From: Laura Gibbons <Laura.Gibbons@arun.gov.uk>
Sent: 01 June 2021 15:36
To: Planning.Responses <Planning.Responses@arun.gov.uk>
Cc: Michael Eastham <Michael.Eastham@arun.gov.uk>
Subject: RE: Planning Consultation on: A/85/21/DOC

Application No: A/85/21/DOC

Site Address: Land at Dappers Lane Angmering Littlehampton

Description of Works: Approval of details reserved by condition imposed under ref A/76/20/PL relating to Condition Nos 17 - existing & proposed ground levels, proposed finished floor levels, levels of any paths, drives, garages & parking areas & the proposed completed height of development & any retaining walls, 18 - surface water drainage, 19 - maintenance & management of surface water drainage, 21 - discharge flows to watercourses and 22 foul drainage system.

Title **Volumetrics Assessment**

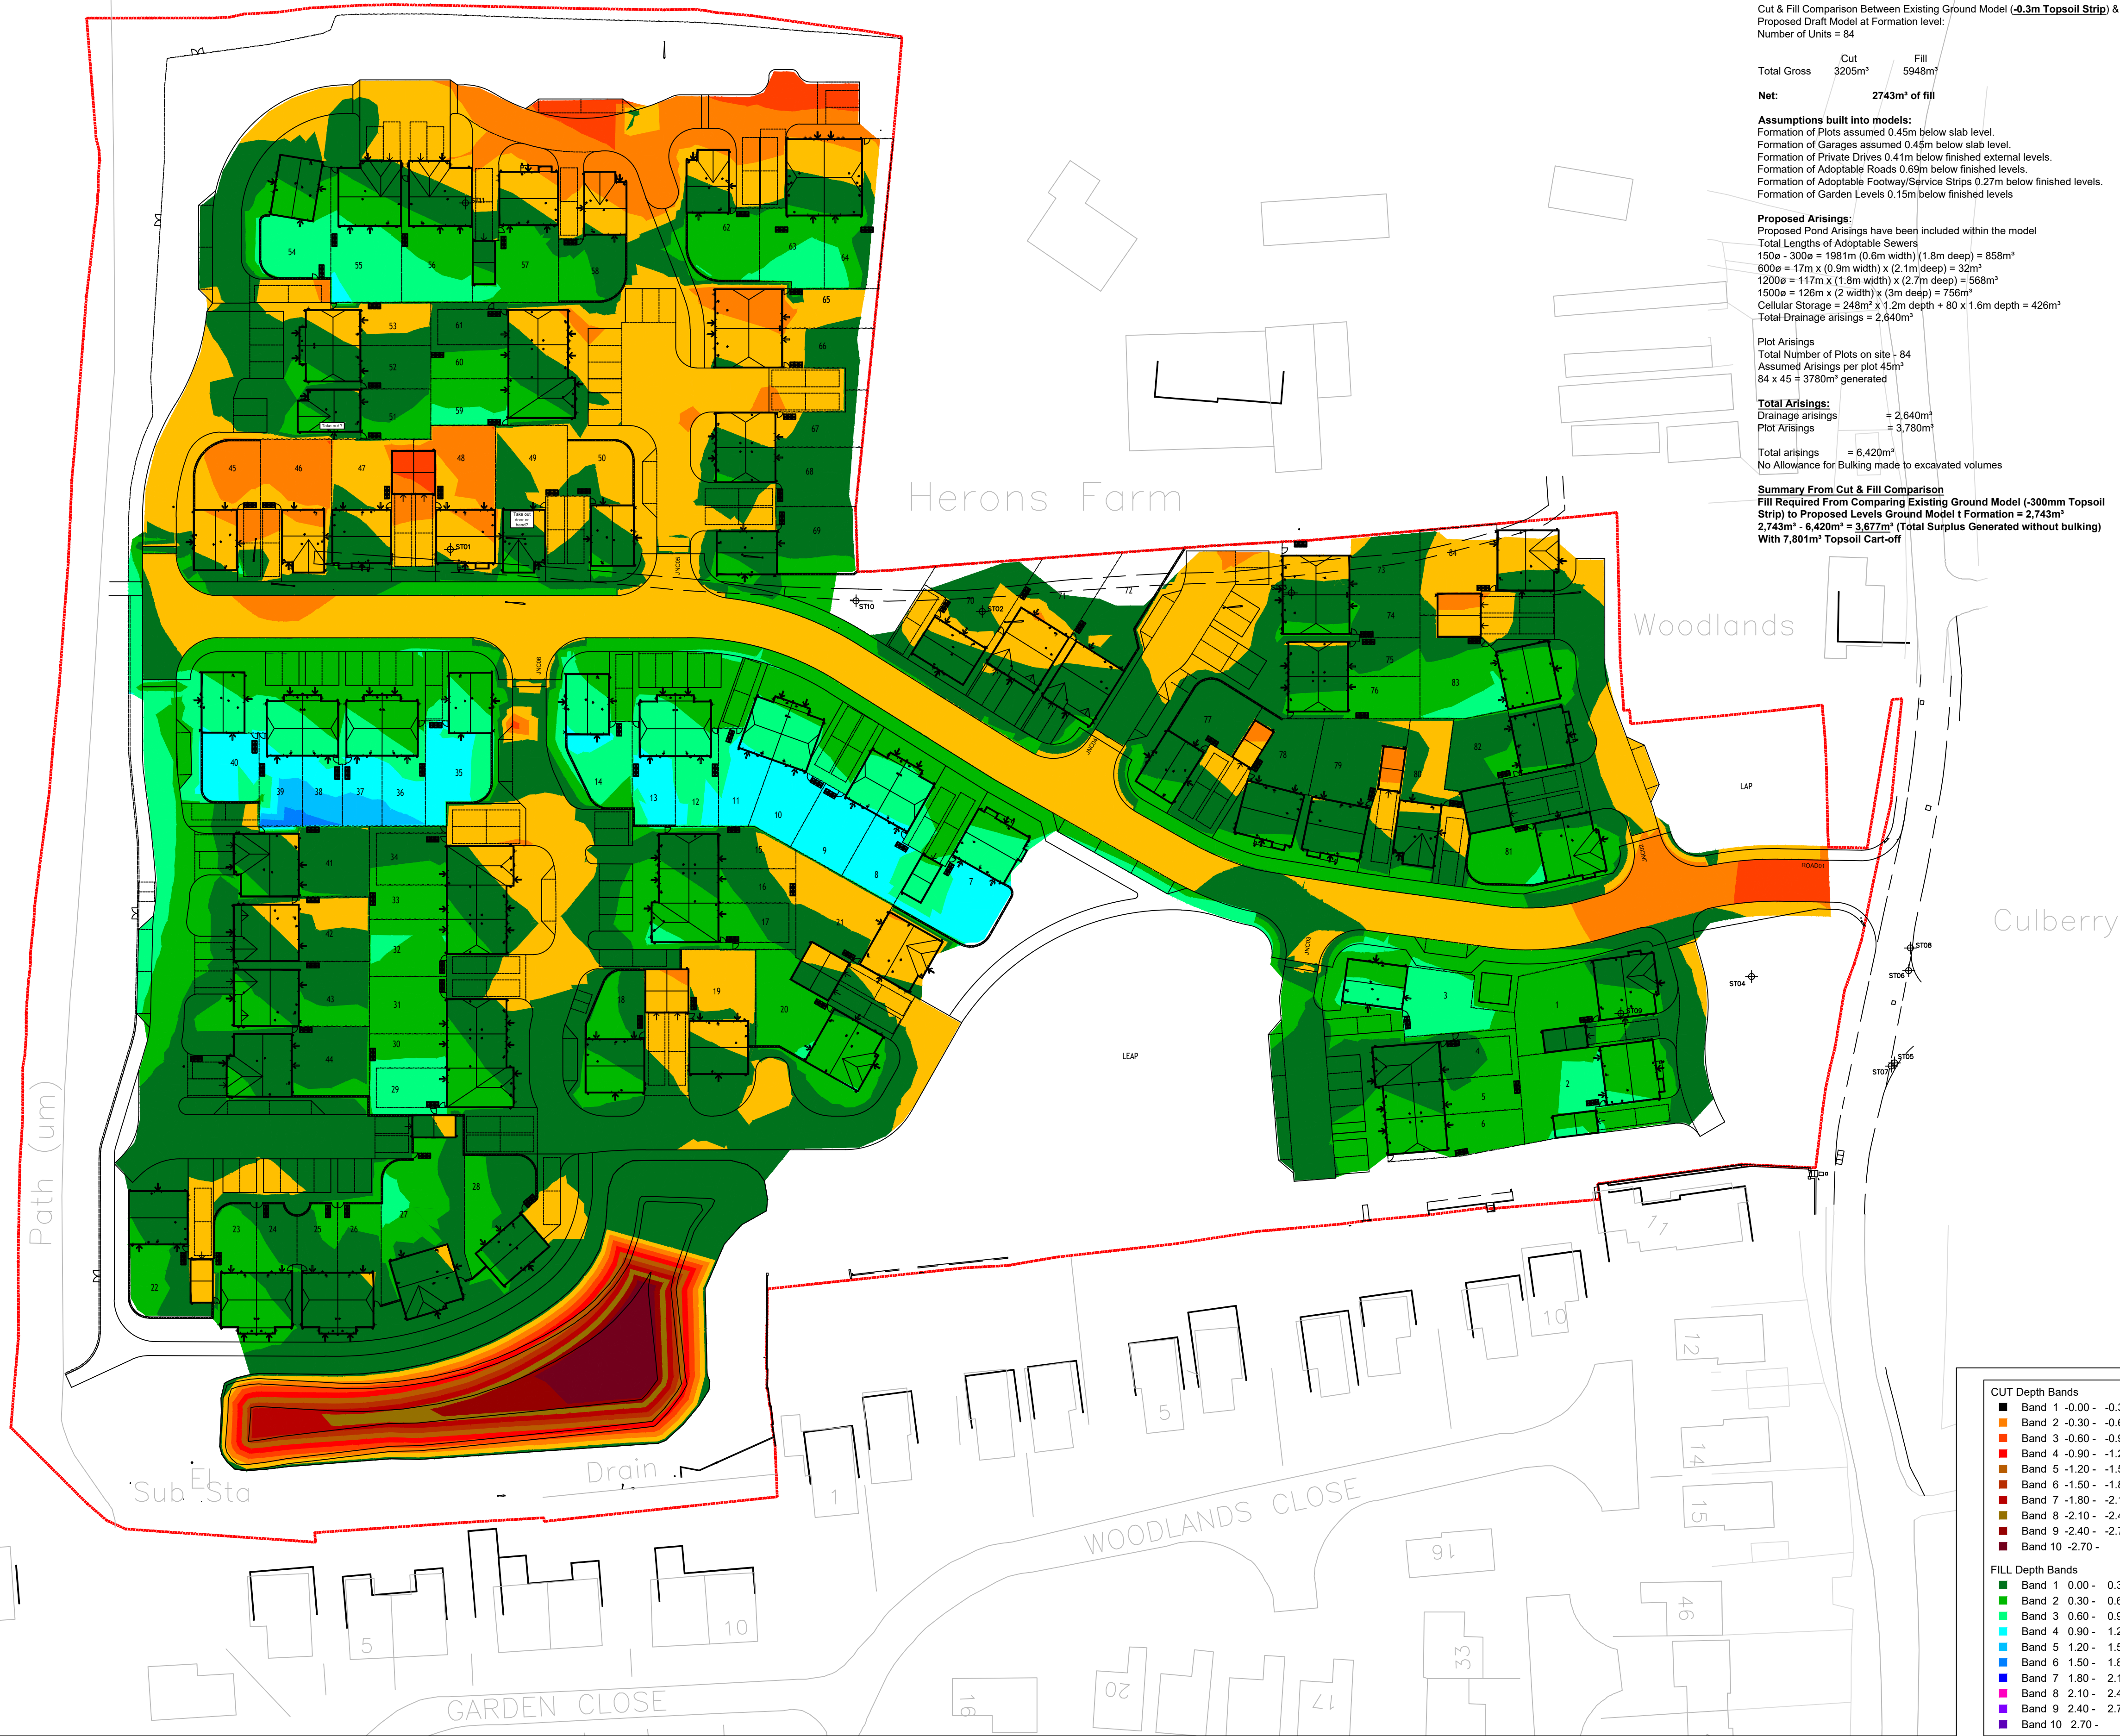
We note that significant land raising of circa 1m is proposed. We do not support this and will need to carefully consider the impacts of any such proposals on adjacent sites in terms of surface water runoff and groundwater levels.
